V2_Grading & Erosion Control Plan_COMMENTS.pdf Markup Summary

EPC Stormwater- Zachary (28)

ASCENT CHURCH

**STORM-01**  
**STA 1+00.00 TO 2+10.23**

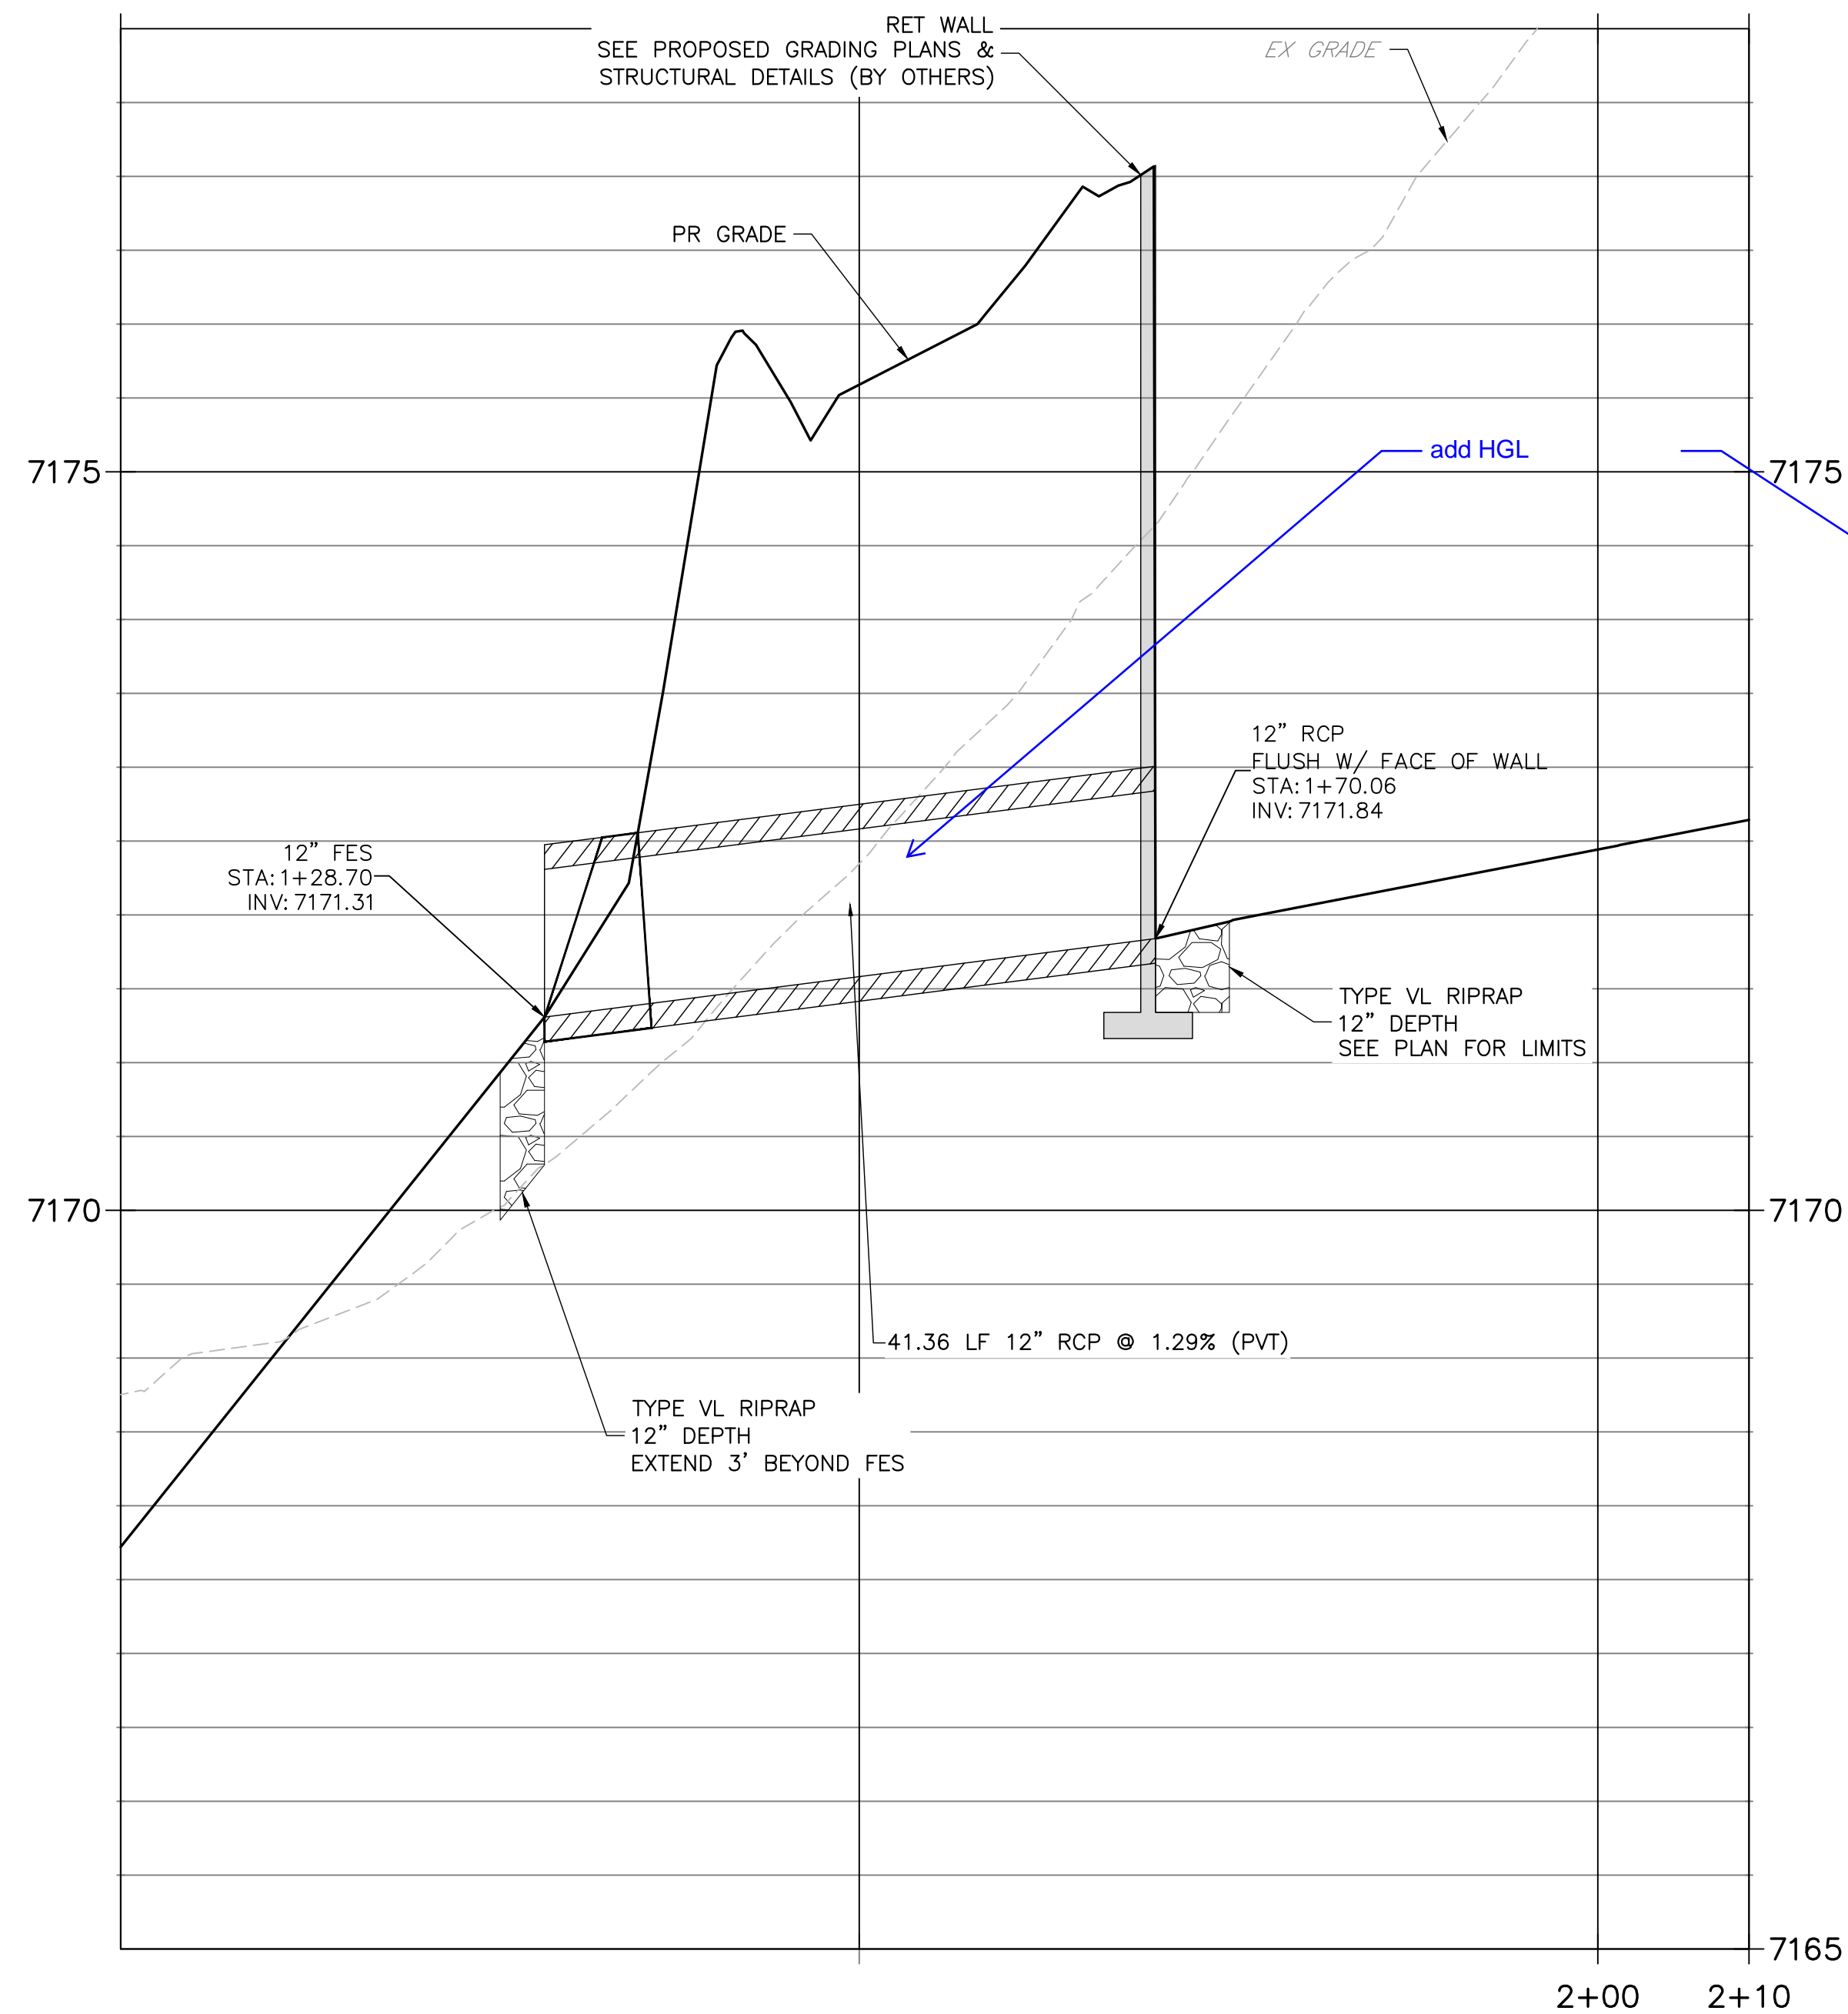
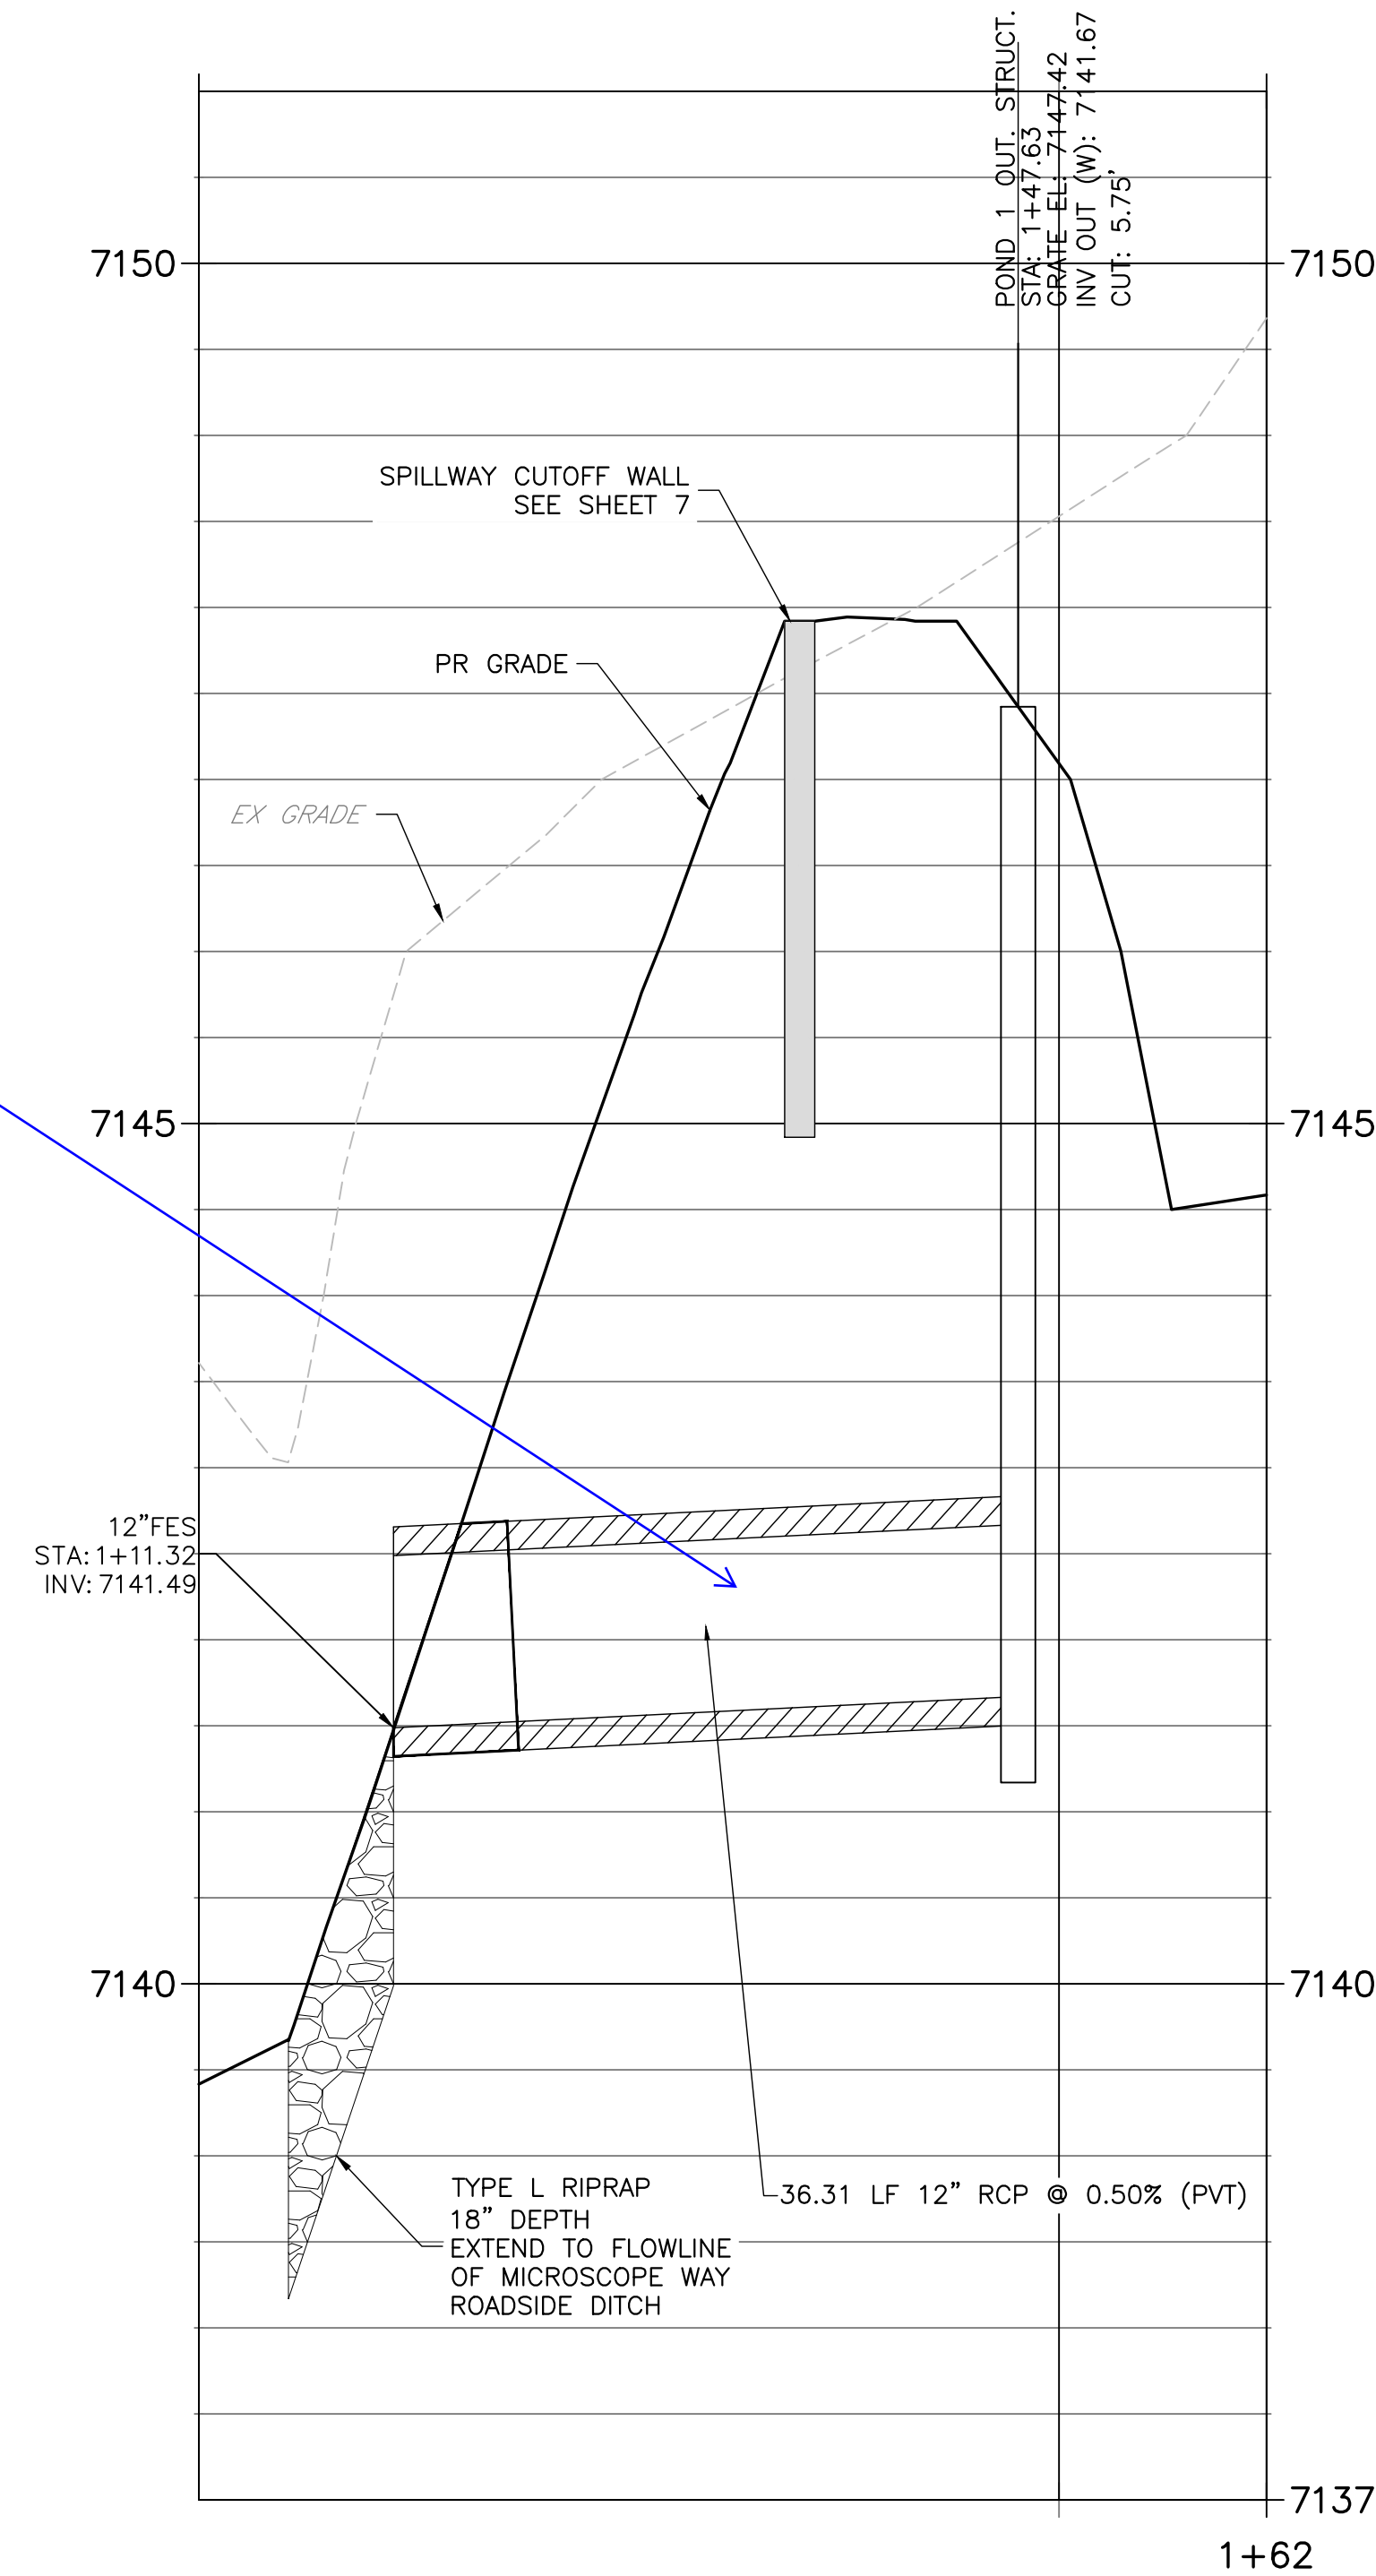
add HGL

**ORIFICE PLATE DETAIL**  
SCALE: 3/4"=1'

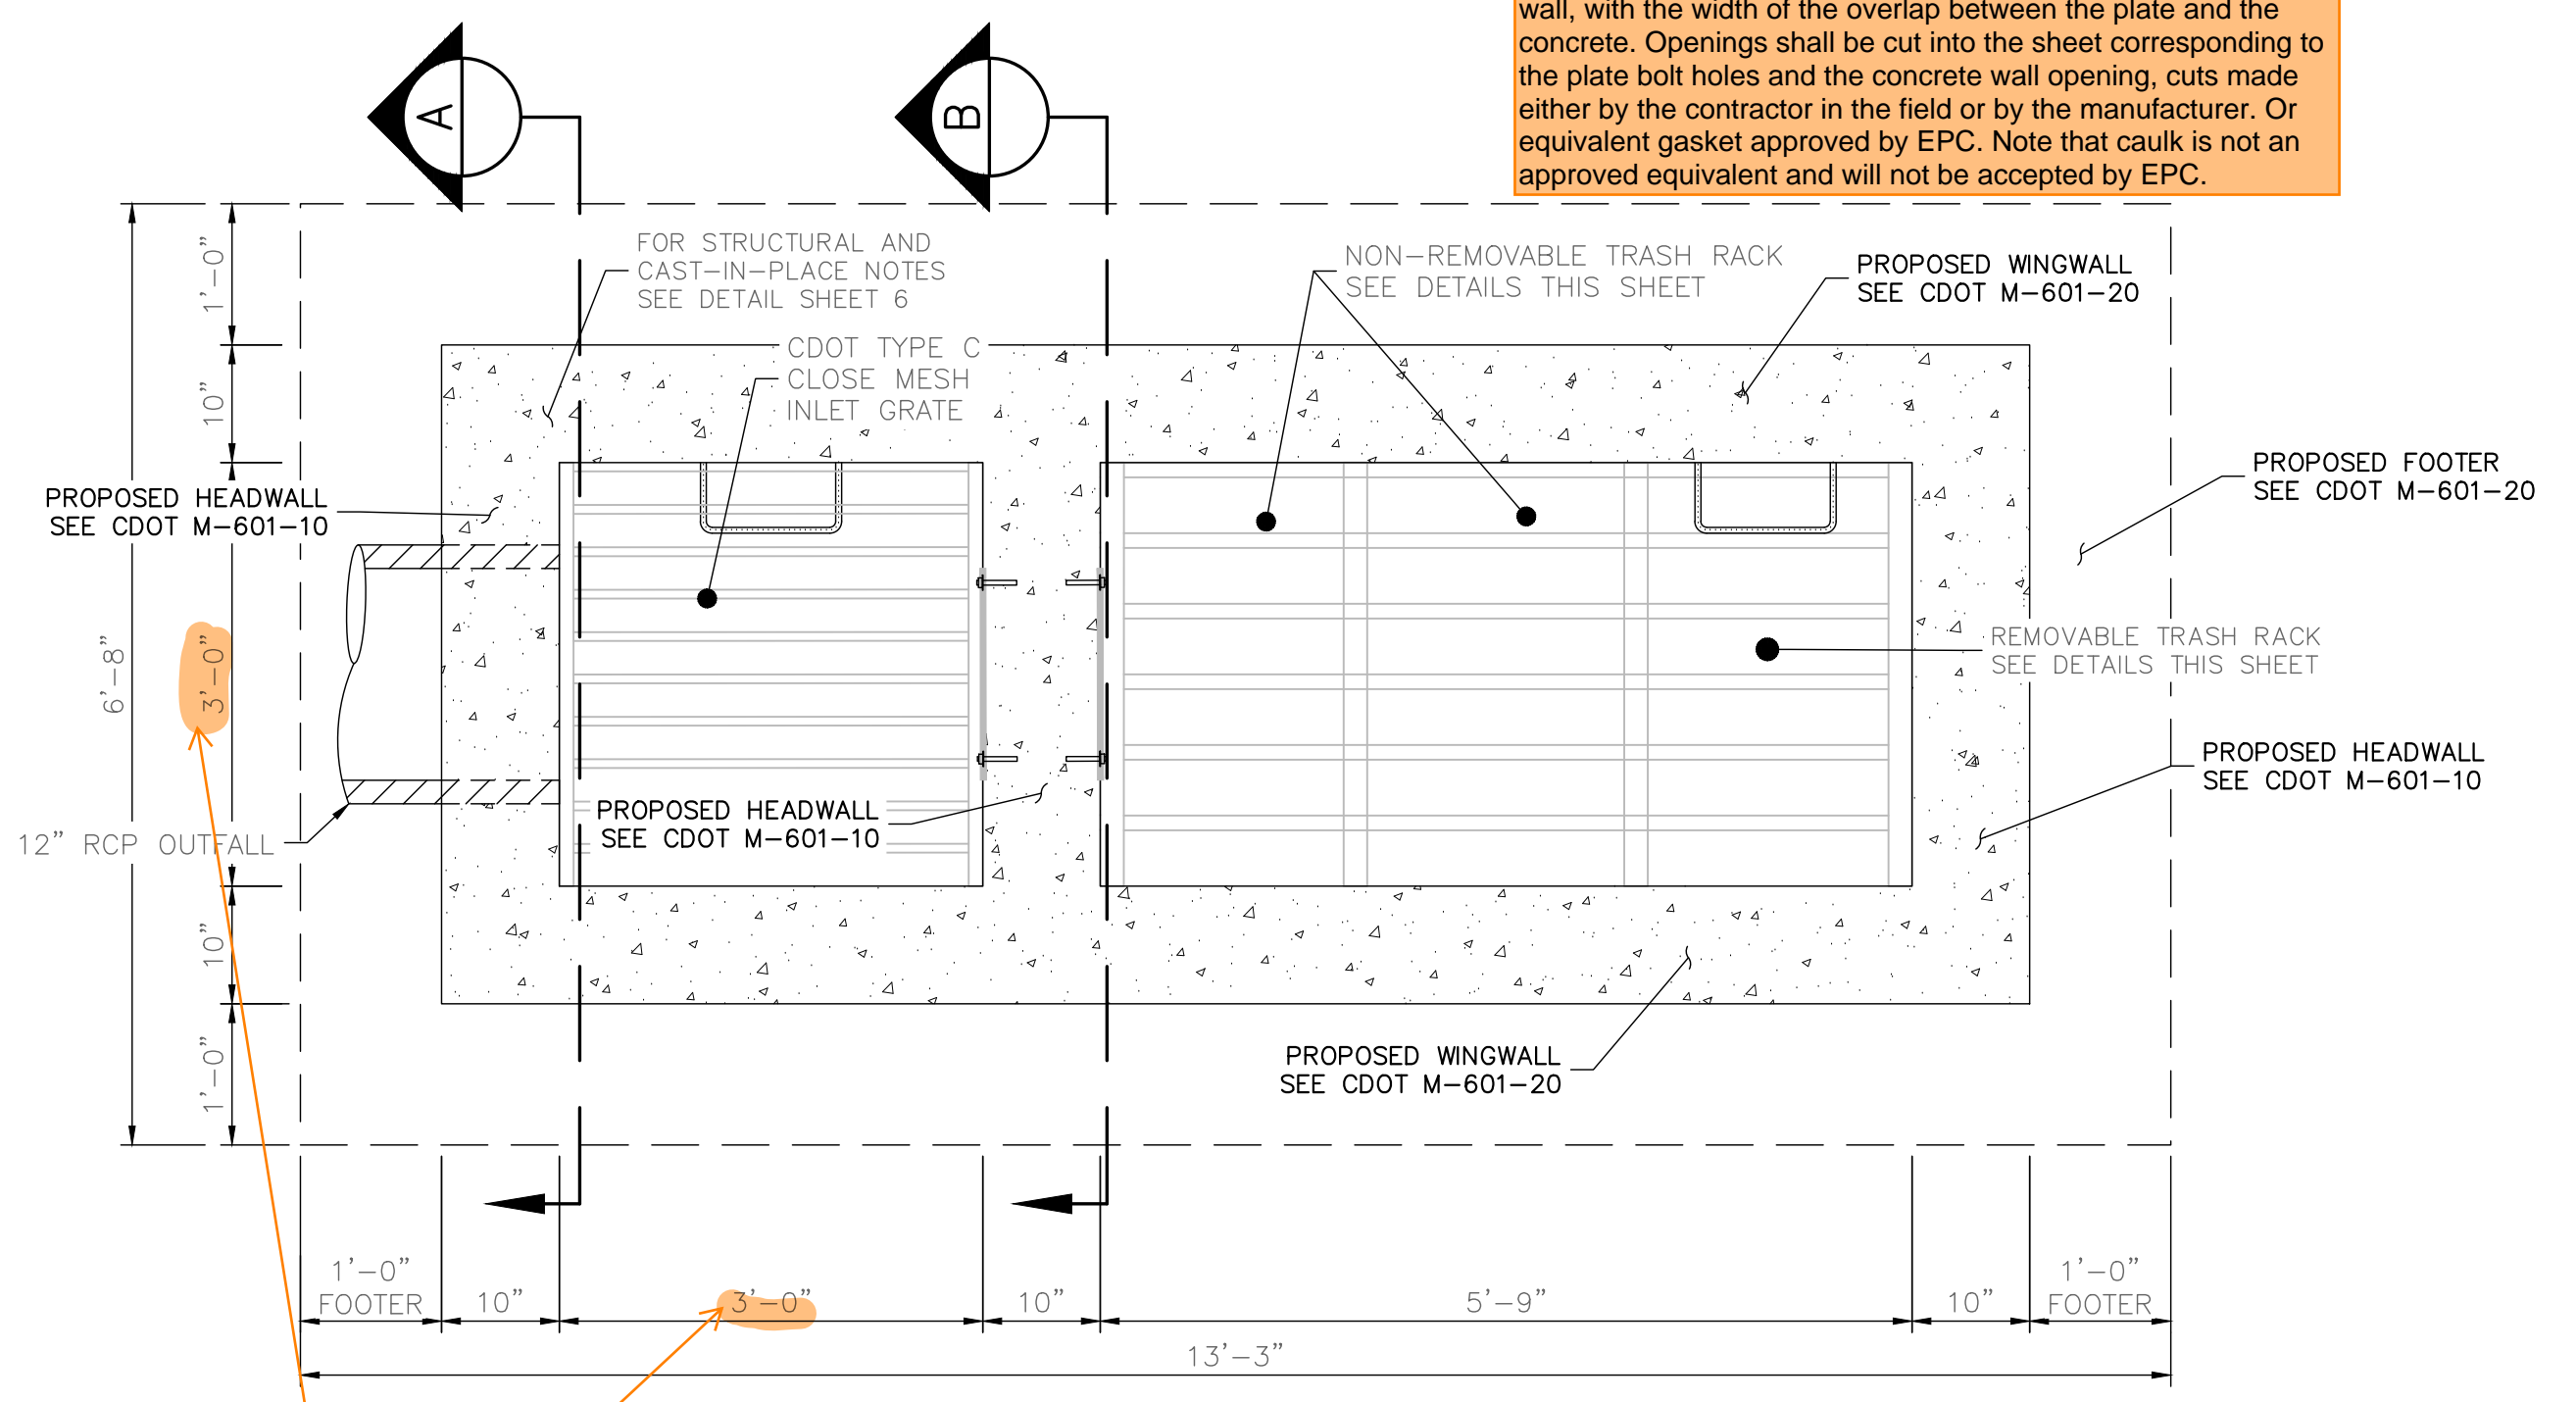
Does not match design spreadsheet

Dimension does not match "height above pipe invert" in design spreadsheet

Provide more detailed gasket info like thickness, width, brand/model, etc.

When orifice holes are smaller than 1.25" in diameter, please specify Johnson stainless steel well screen with #93 VEE wire (Figure 6-a), or equivalent

This detail shows the trickle channel sitting above the pond bottom, please revise so the top of the concrete curb is flush with the pond bottom

Per DCMv1 Section 4.3 (UD Figure 6-a) and DCMv2 Section 11.3.1 (1st paragraph), outlet pipe should be 18" minimum.

Clarify that the top of the wingwall matches the path of the trashrack

Based on input gathered from industry experts, below is the recommended gasket spec:

The gasket shall be made of 1/4-inch thick, 60 durometer EPDM rubber in a continuous sheet the size of the orifice plate. The sheet shall be placed between the orifice plate and the concrete wall, with the width of the overlap between the plate and the concrete. Openings shall be cut into the sheet corresponding to the plate bolt holes and the concrete wall opening, cuts made either by the contractor in the field or by the manufacturer. Or equivalent gasket approved by EPC. Note that caulk is not an approved equivalent and will not be accepted by EPC.
